Following the SSD application for New Liverpool Primary School, we received Response to Submissions from DPIE. Please see below responses to comments:

PROJECT NO.	DRAWING NO.
22102	NLPS-AR-DRG-SSD-1103

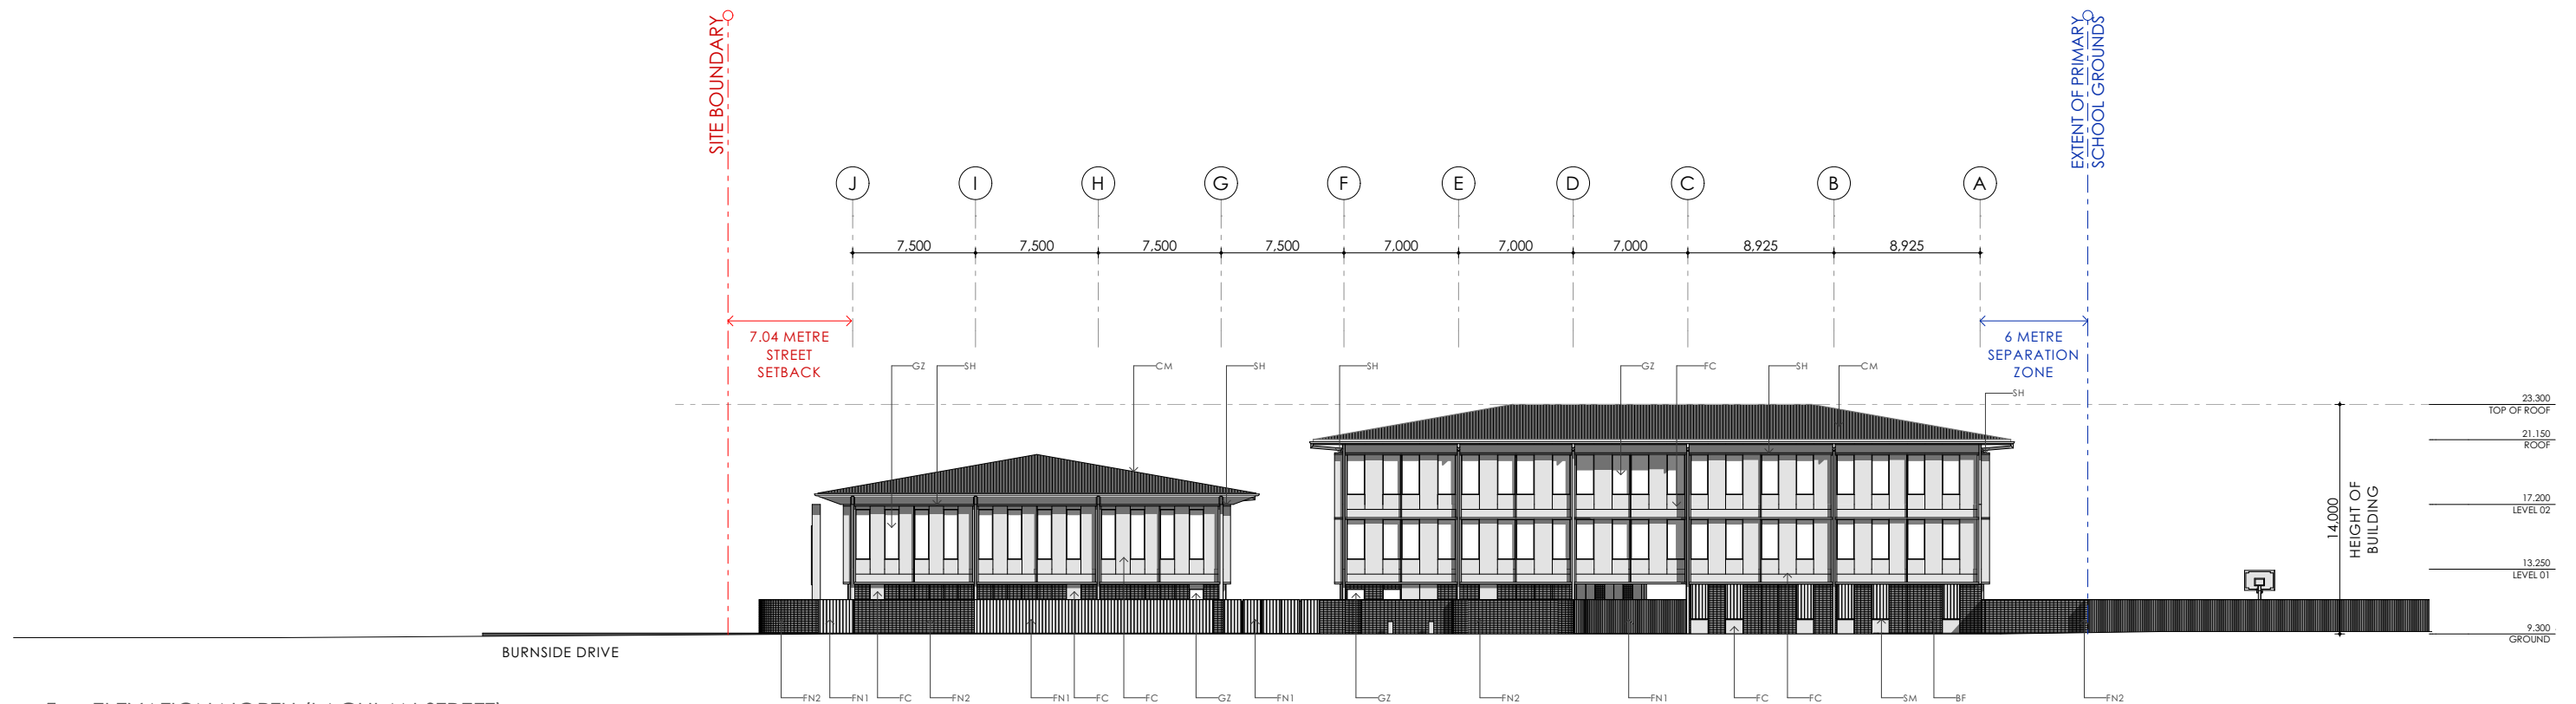
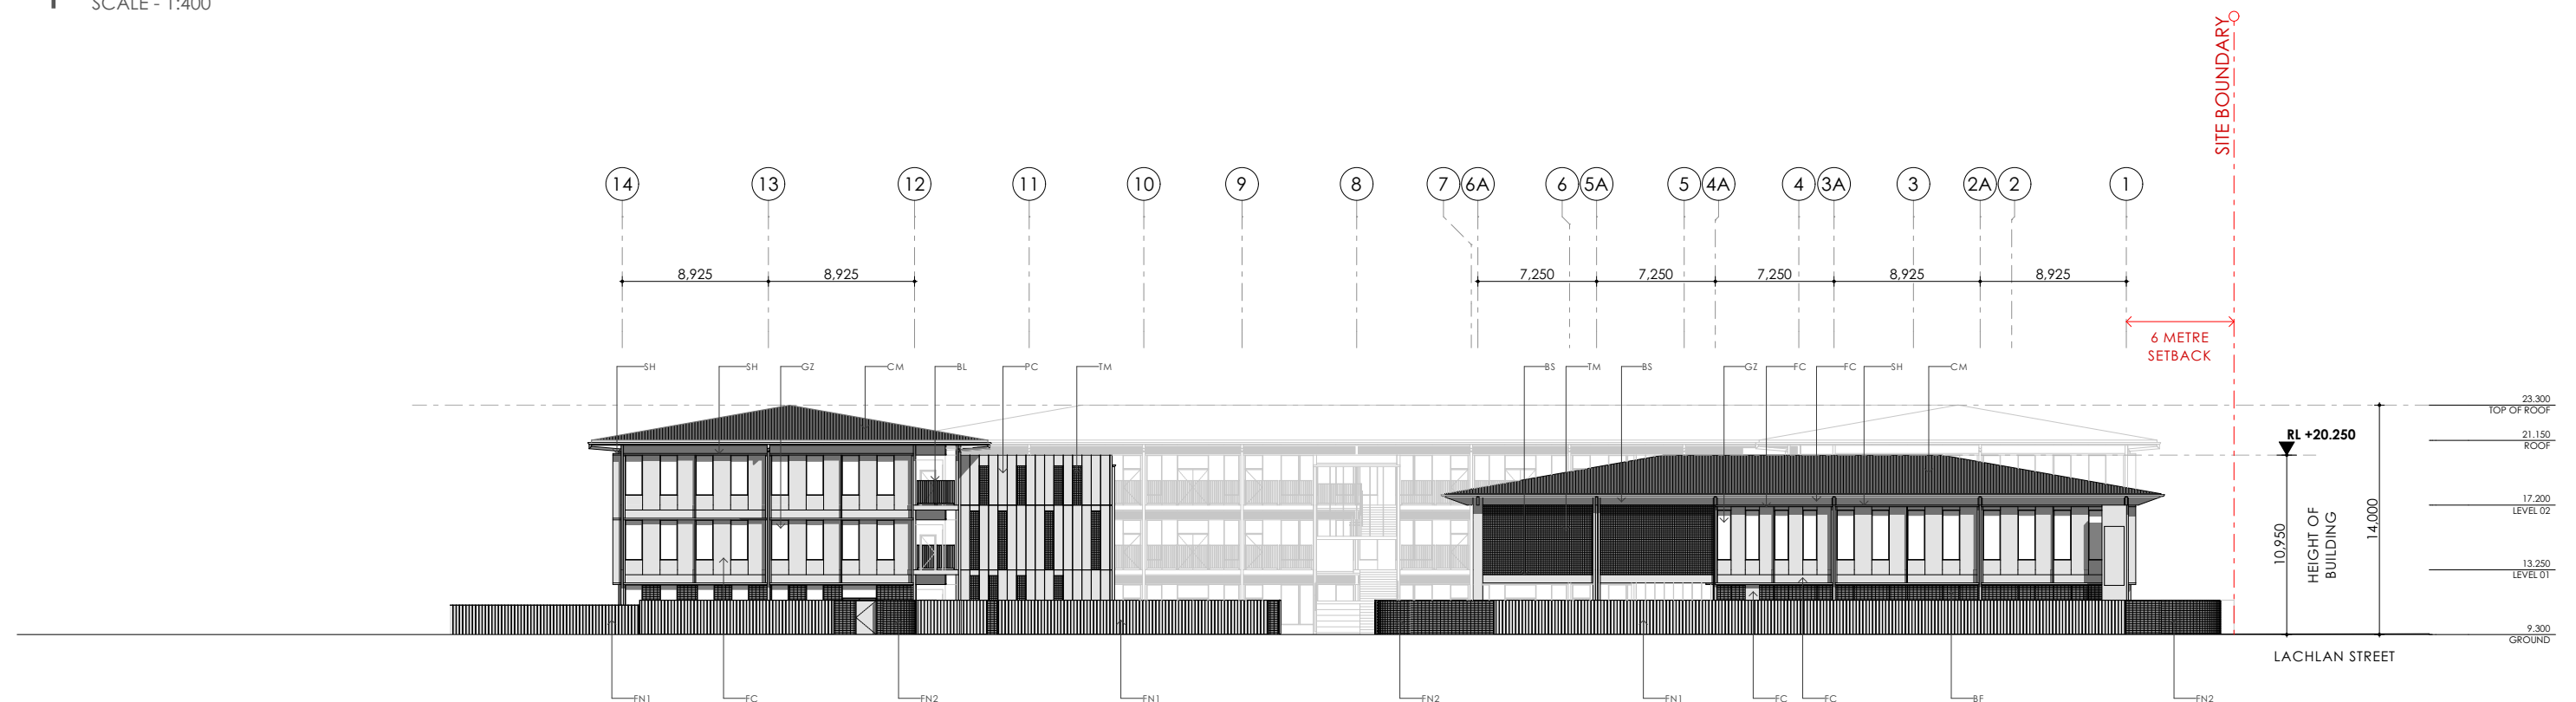
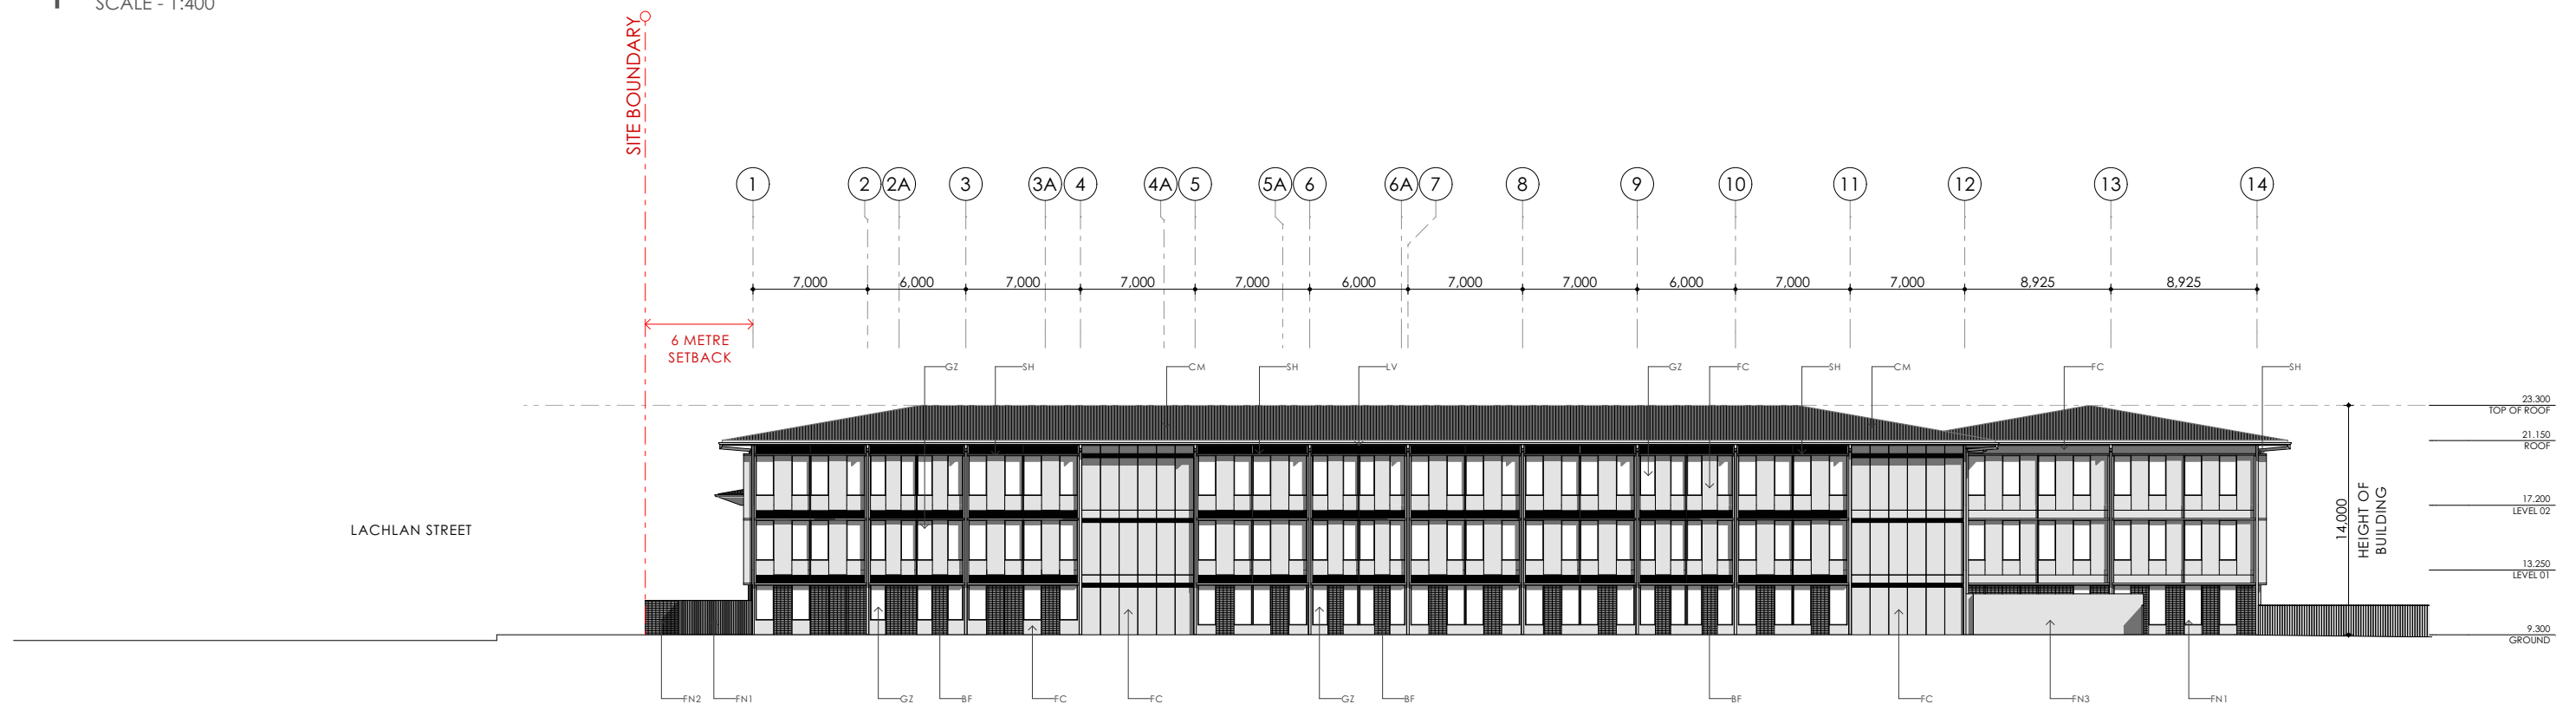
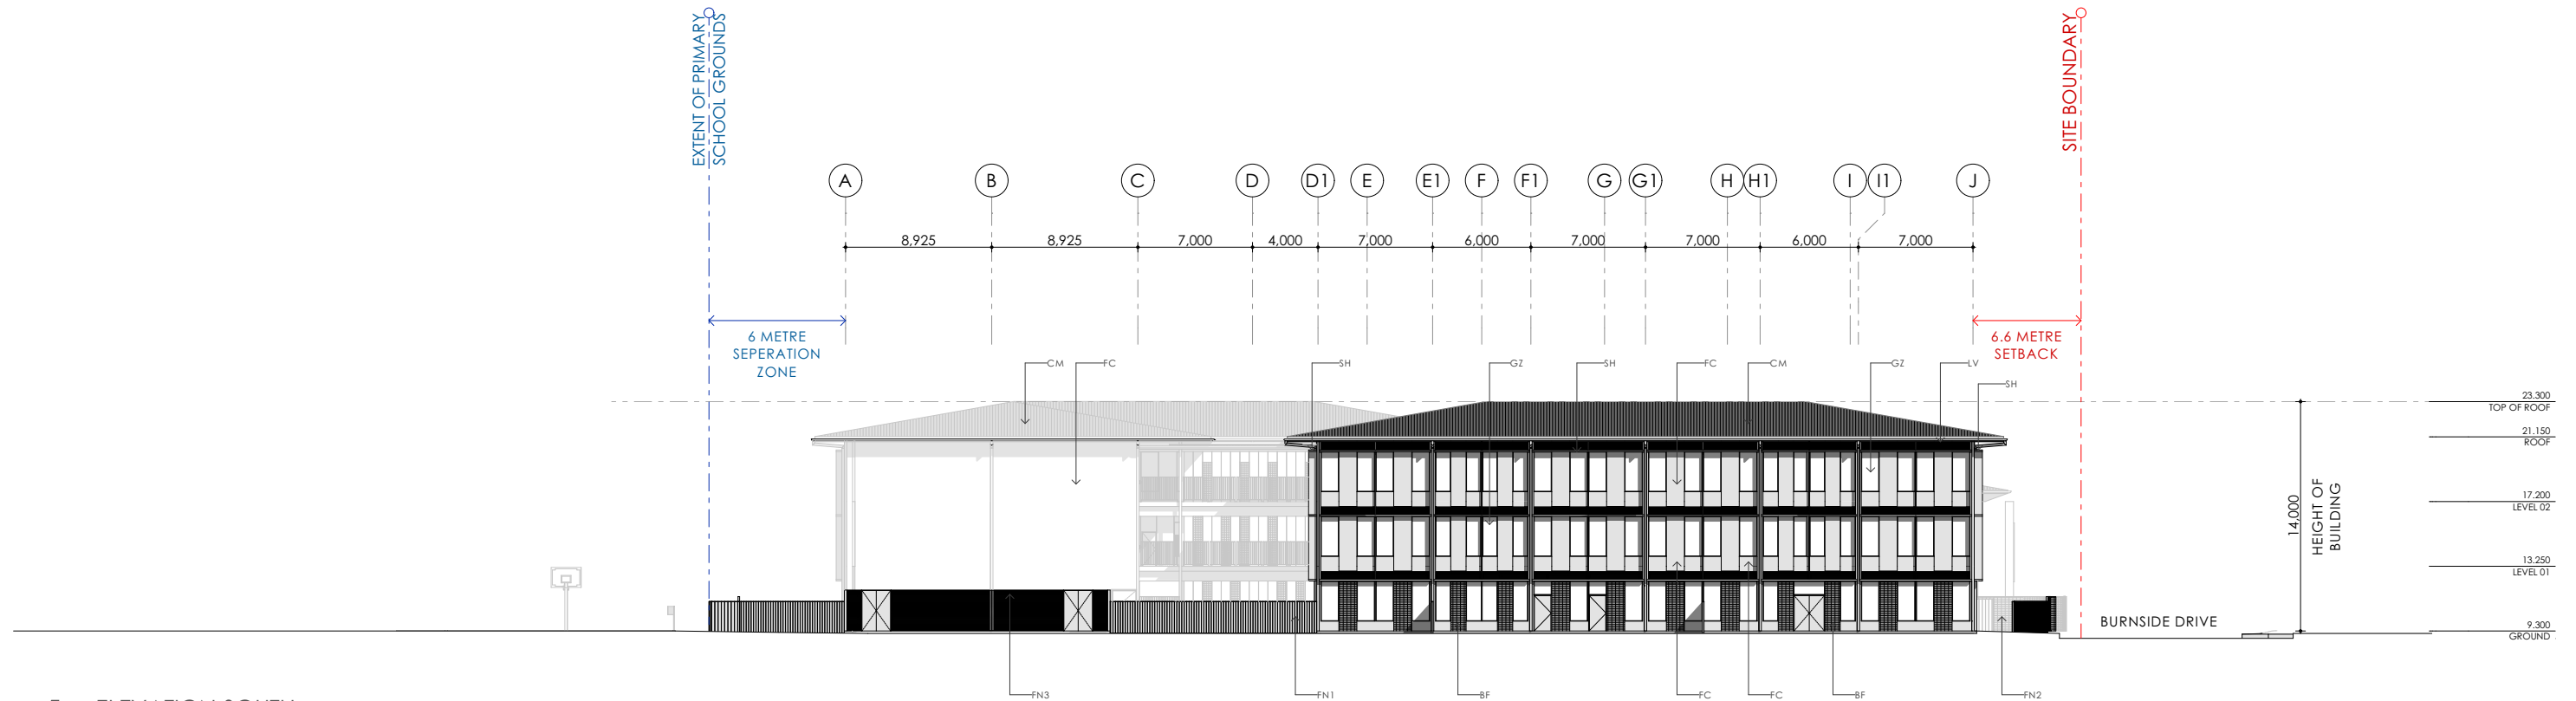
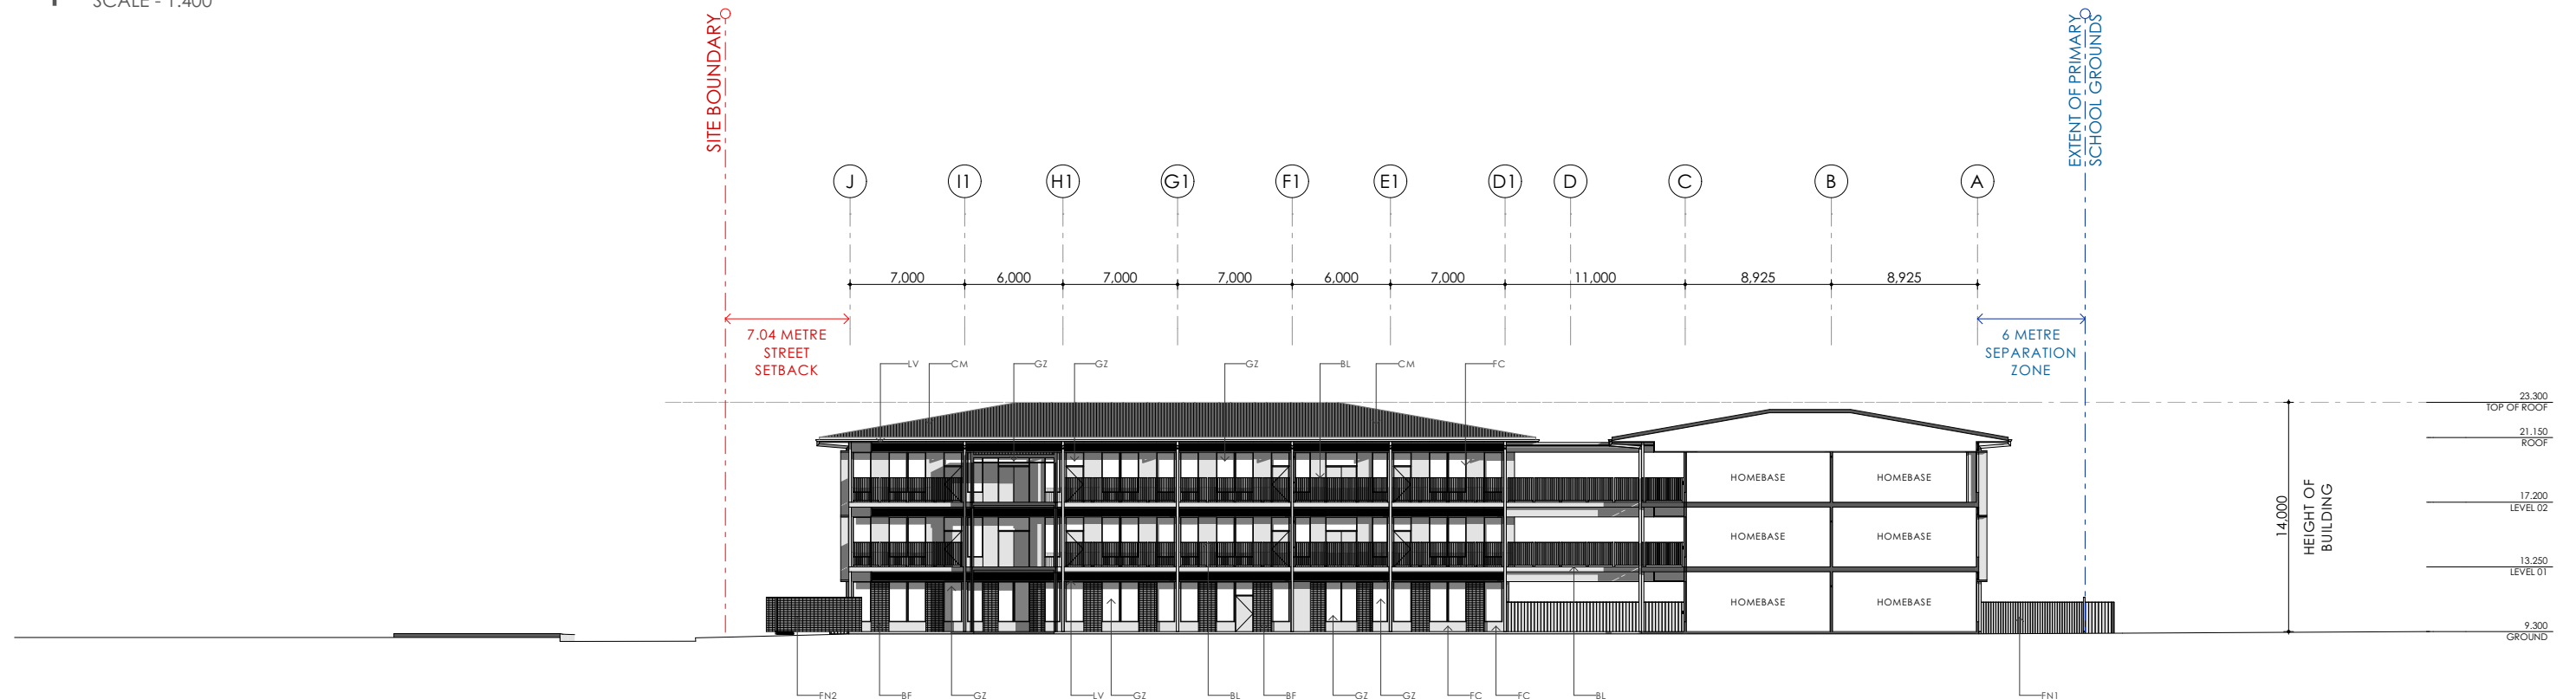
Government Architect NSW (GANSW) have reviewed the EIS and have raised concerns regarding the full height glazing to the Western façade with no shading and no planting able to be facilitated along the boundary. In recognition of the western elevation, you are requested to address this issue and provide additional shading devices or articulation of this façade which can result in shading.

500mm deep vertical and horizontal sunshades have been provided to the Western façade which work with the ratio of 30% performance glazing to 70% solid façade to achieve a compliant Solar Heat Gain Coefficient of 0.6. Mid-Summer shading studies on the Western Façade show how eaves horizontal projections mitigate midday sun into West facing spaces.
